8 April 2020

Exhibition comments - Horsley Drive Stage 2 – Building 1 (SSD 10404)

CLAY PRESHAW
Manager Catchment Protection

DRAWING TITLE
CONCEPT STORMWATER PLAN
SHEET 1
DRAWING No Co114.92.18- DA41

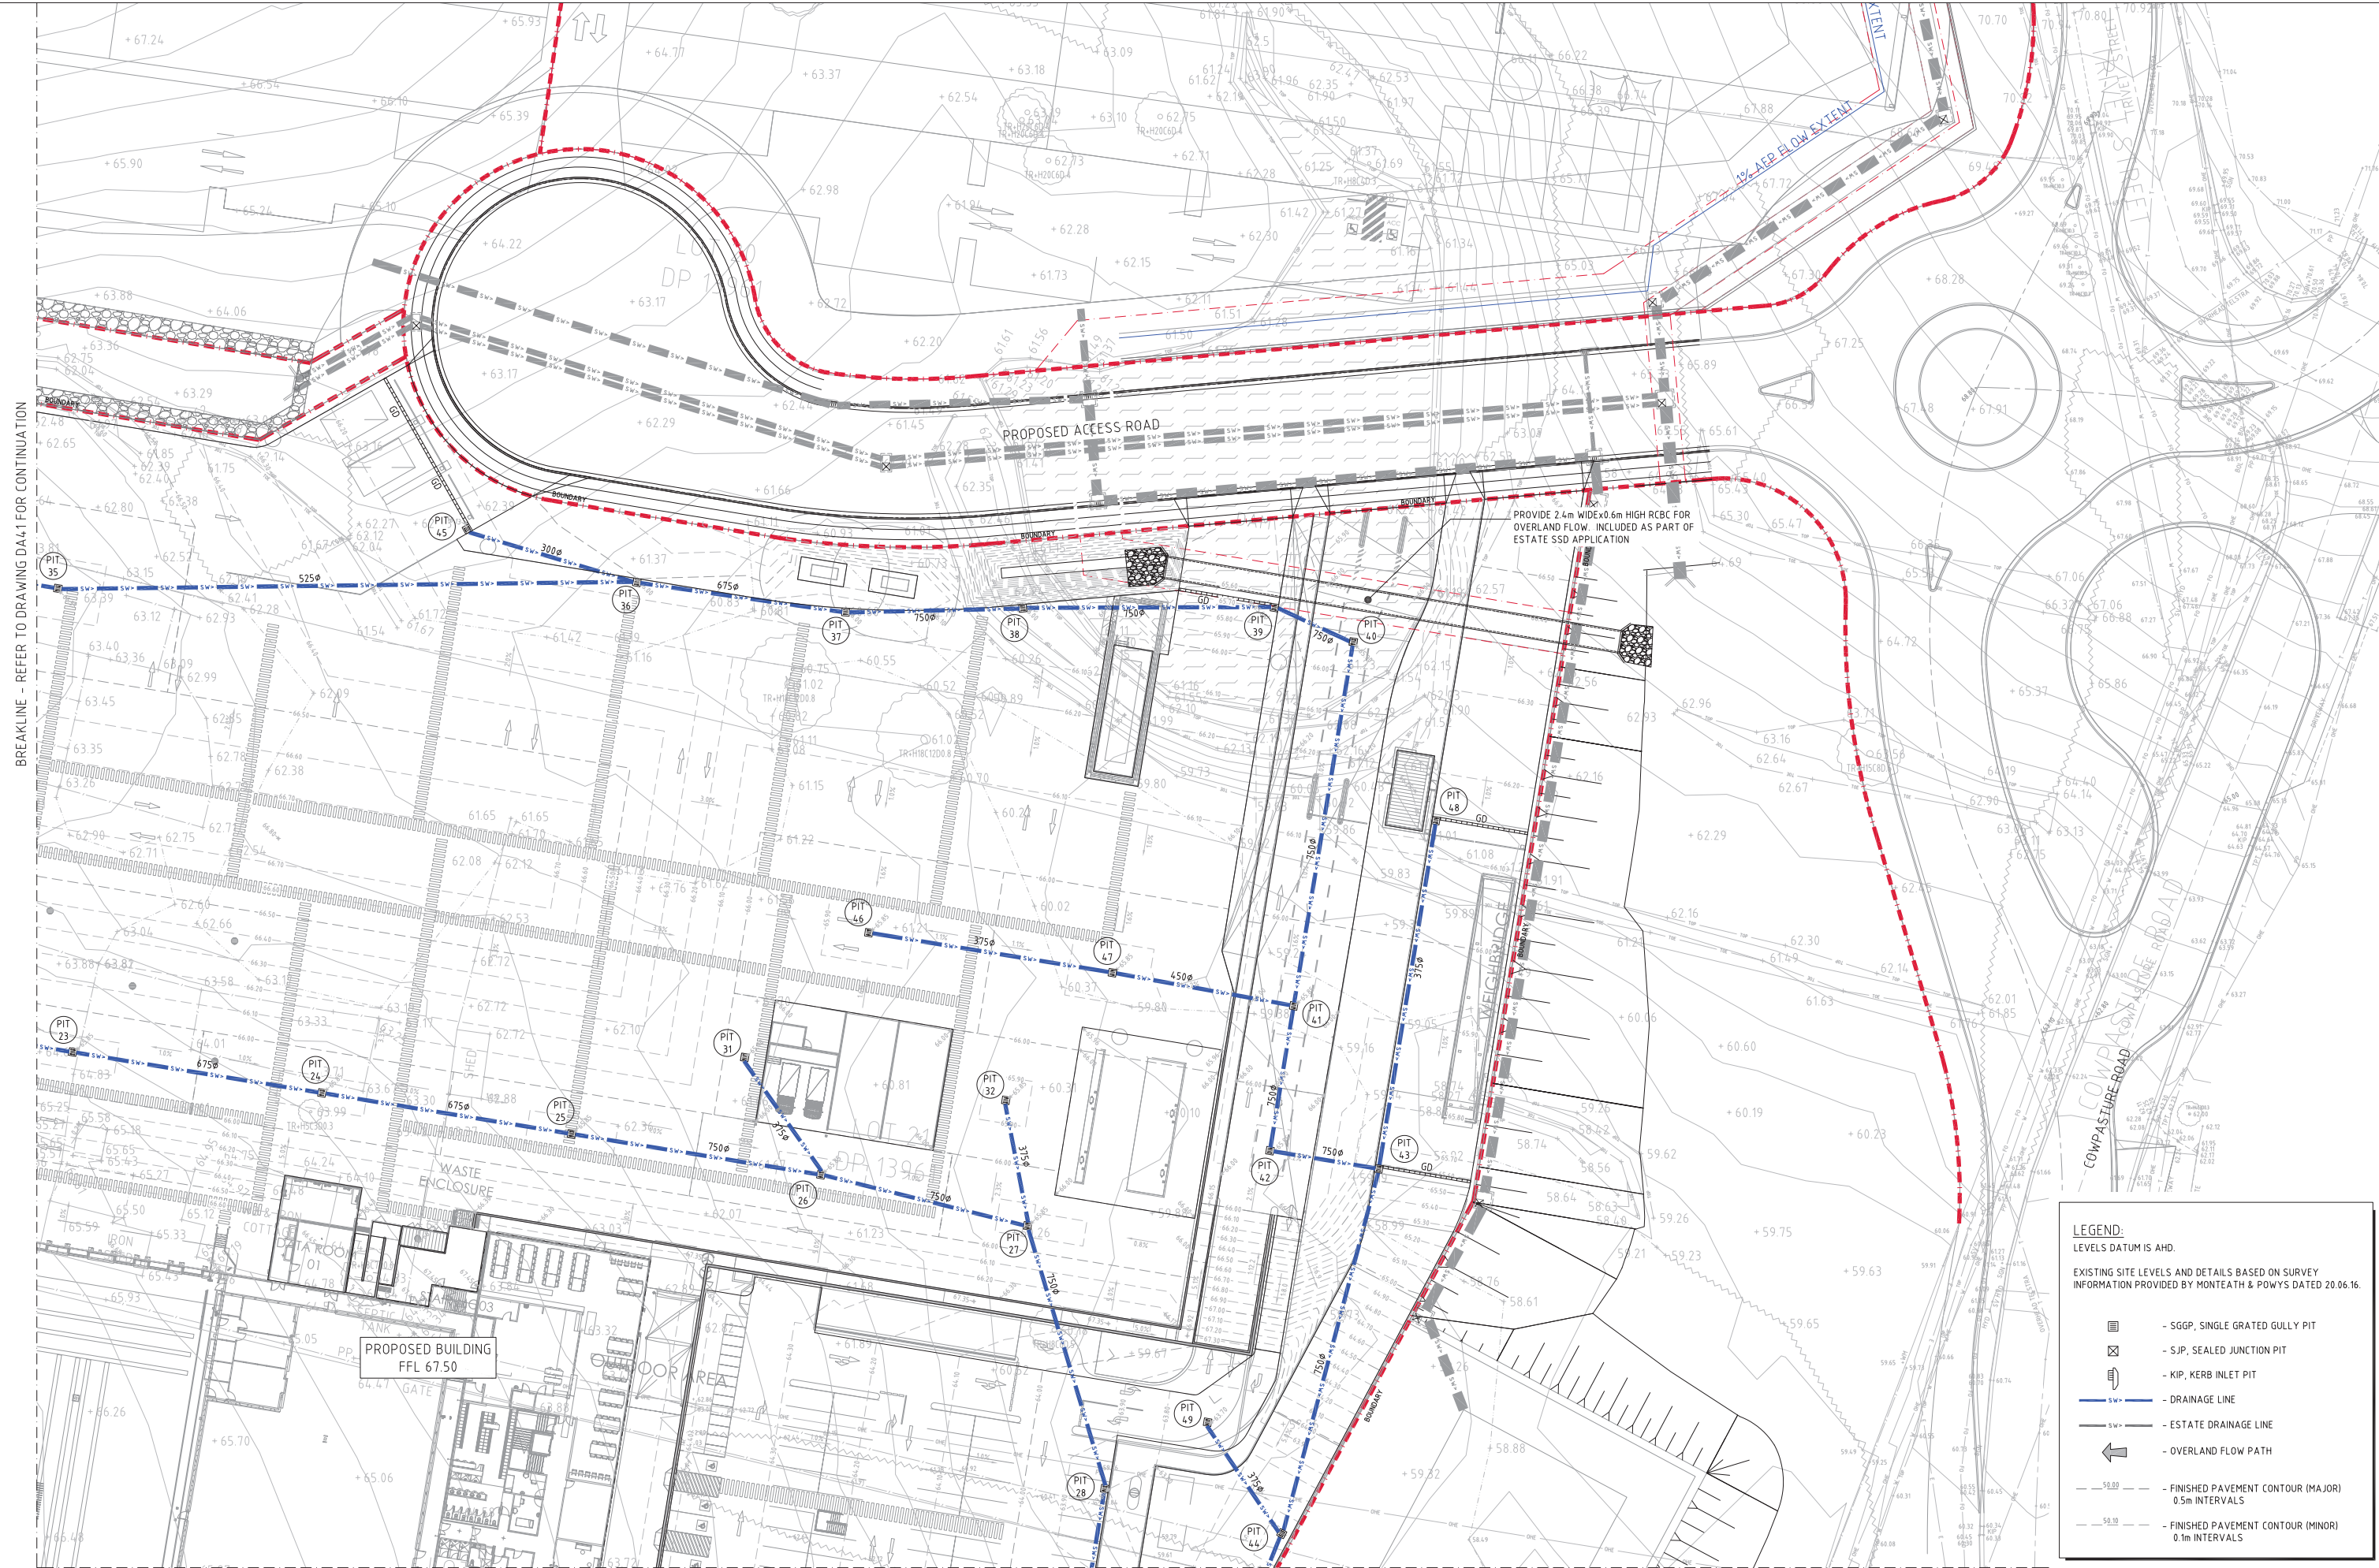
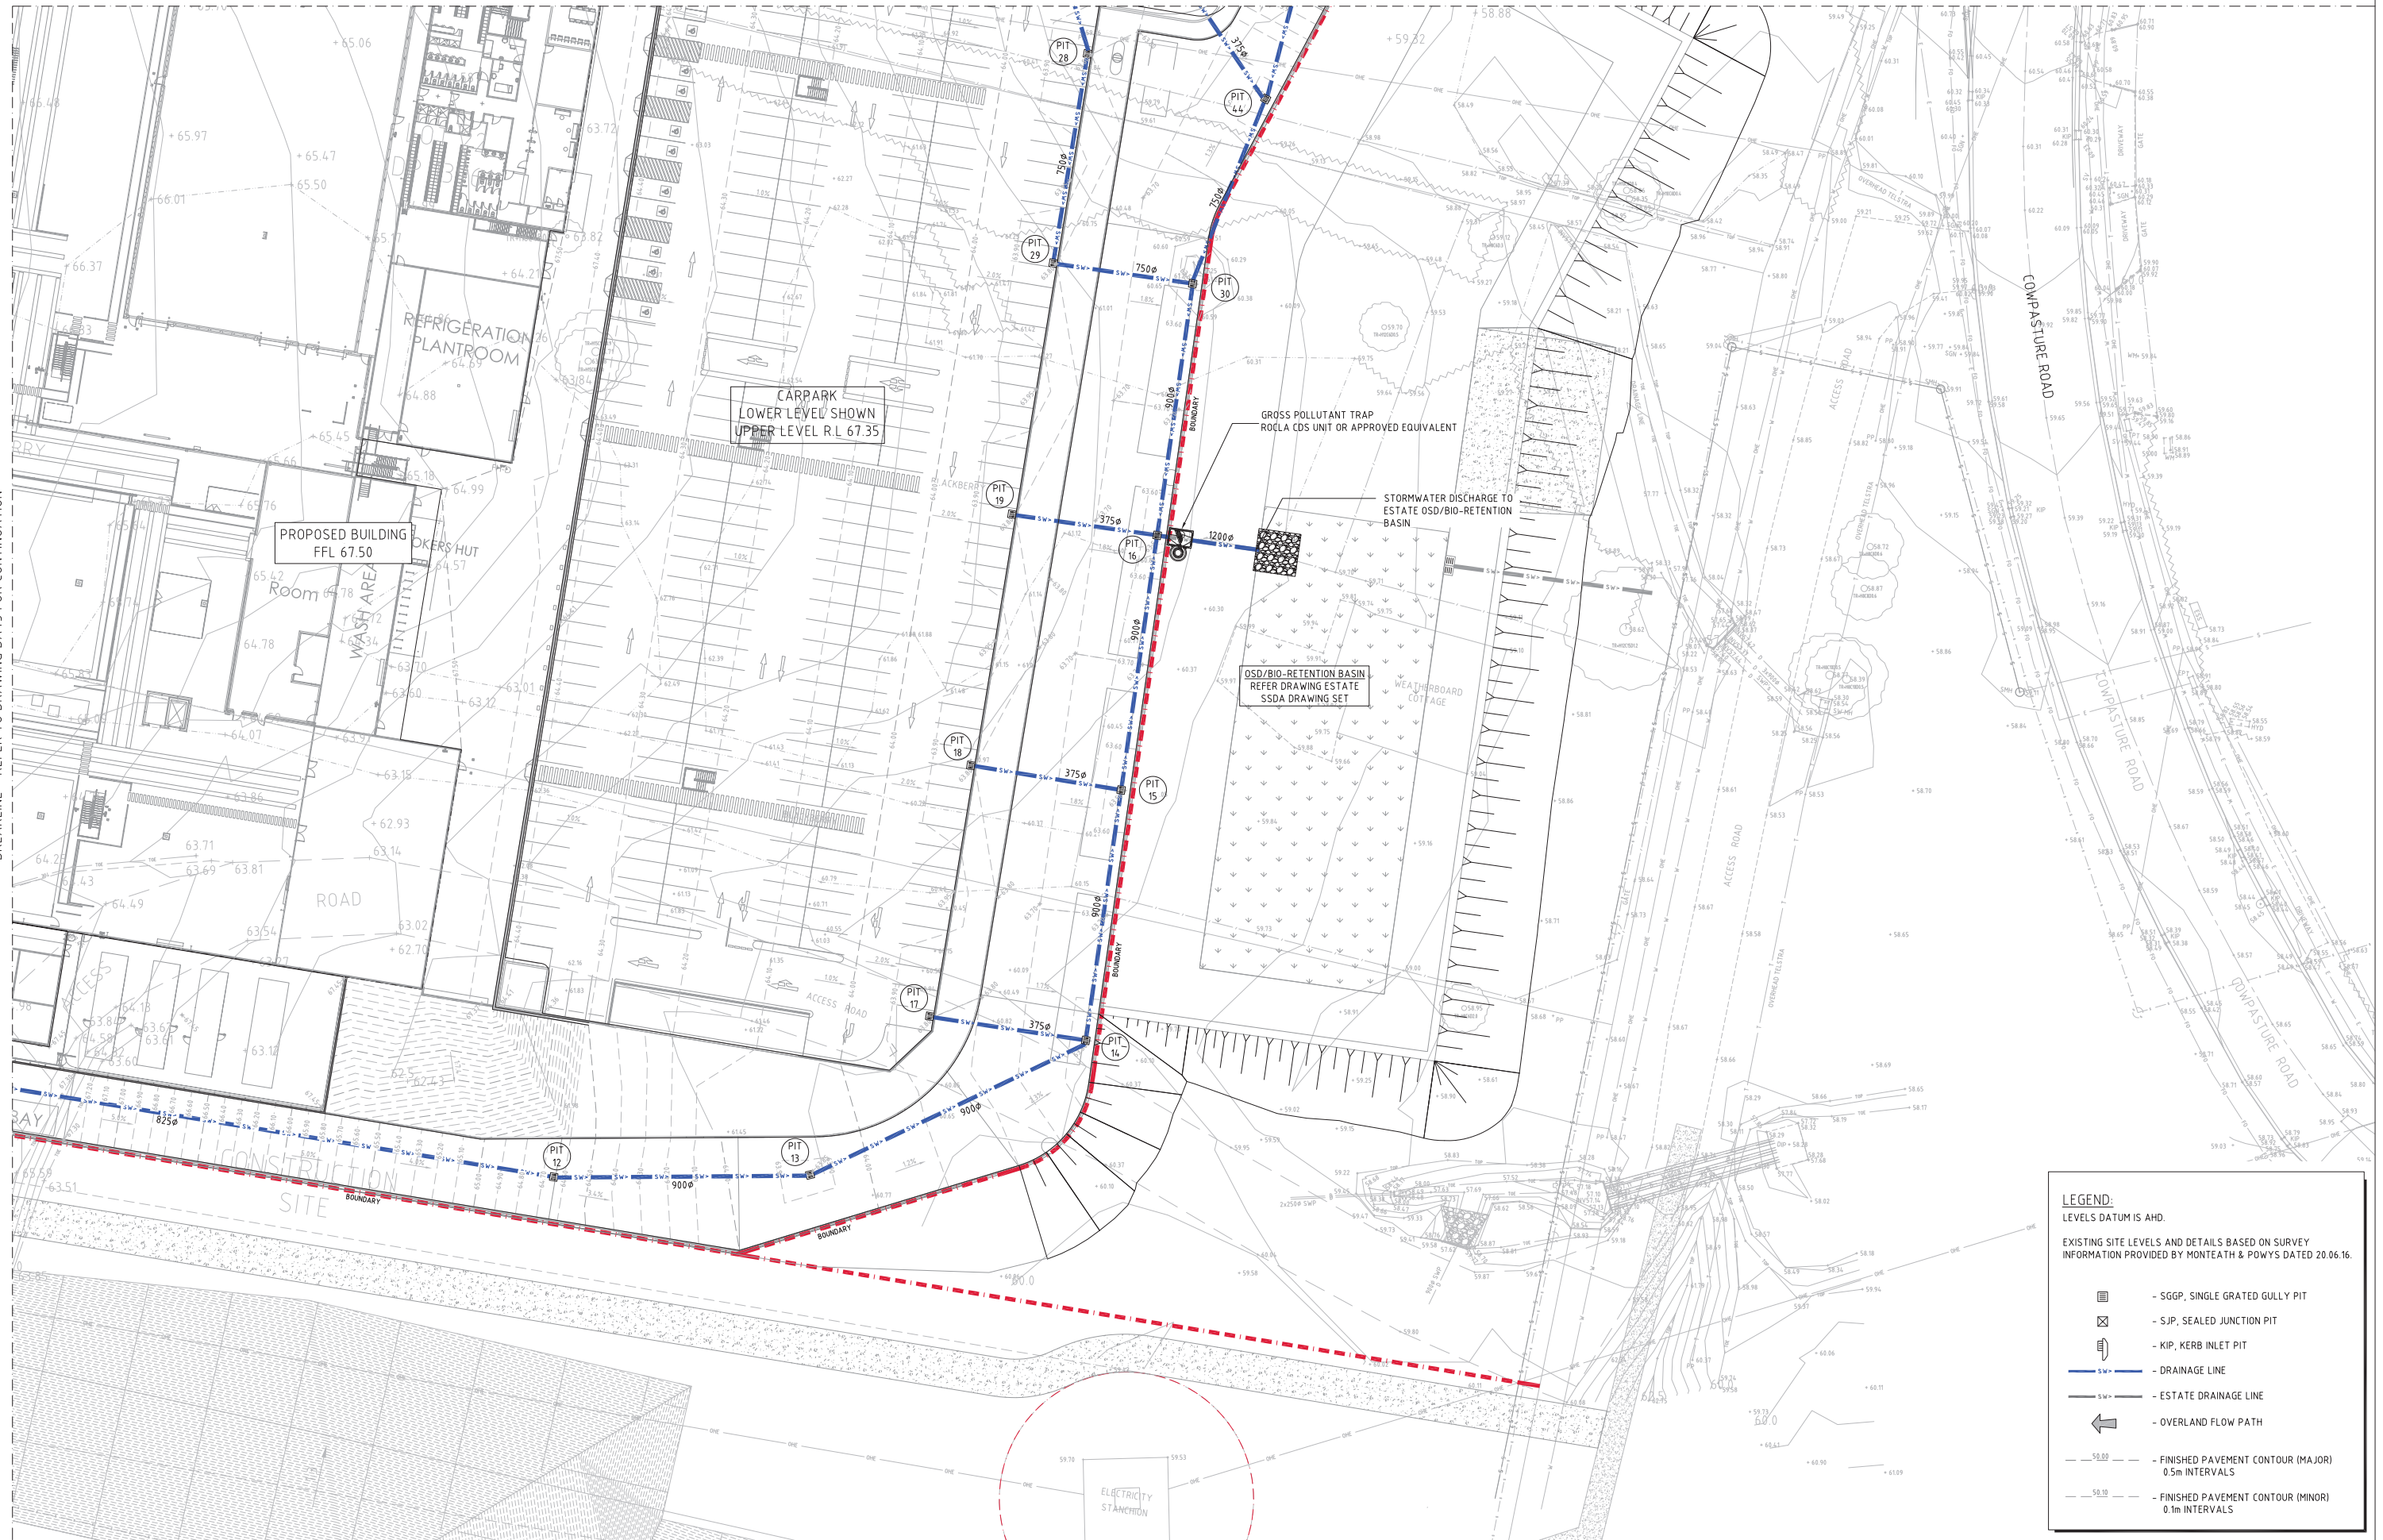
WaterNSW notes the Engineering Report (Costin Roe Consulting, Rev A, 27 February 2020) considers the upstream flows from the Upper Canal corridor that drain onto the subject site.

- *The stormwater system for the site must be designed so as not to either impede upstream flows from the Upper Canal corridor or stormwater structures, nor result in increased flows onto WaterNSW land from the site.*
